Our Ref: WA/13/22/NMA

**Section 96A of the Town & Country Planning Act 1990 (as amended)
Town and Country Planning (Development Management Procedure) (England) Order 2015
(as amended) - Article 10**

Non-material amendment following grant of WA/65/20/PL for the addition of opaque glass window 450mm x 450mm at 1100mm from the floor on east aspect of first floor of oak framed barn building and the addition of a standard external door on both east and west aspects of the same barn.

Little Box Cottage Walberton Green Walberton BN18 0AT

PROPOSED ~~ALTERED~~
GABLE ELEVATIONS

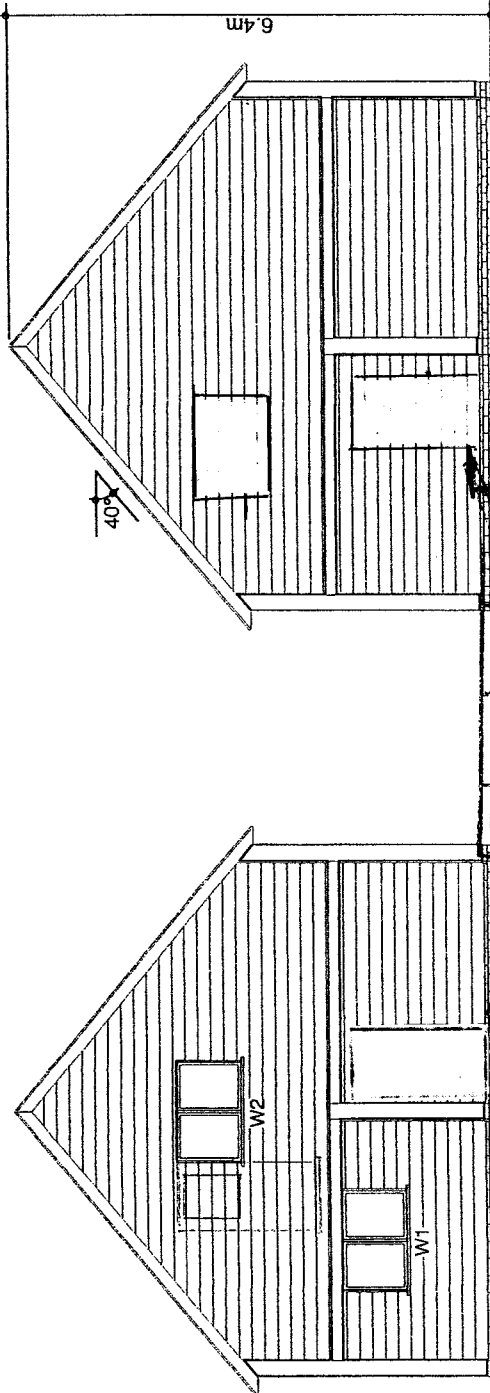
It is proposed to insert of an additional opaque glass window 450mm x 450mm at 1100mm from the floor on east aspect of first floor of oak framed barn building and the addition of a standard external door on both east and west aspects of the same barn. The building is situated in the setting of a Listed Building, within the Conservation Area. The proposal would materially alter the appearance of the building and it would warrant re-consultation and it cannot therefore be considered under section 96A of the Town and Country Planning Act 1990.
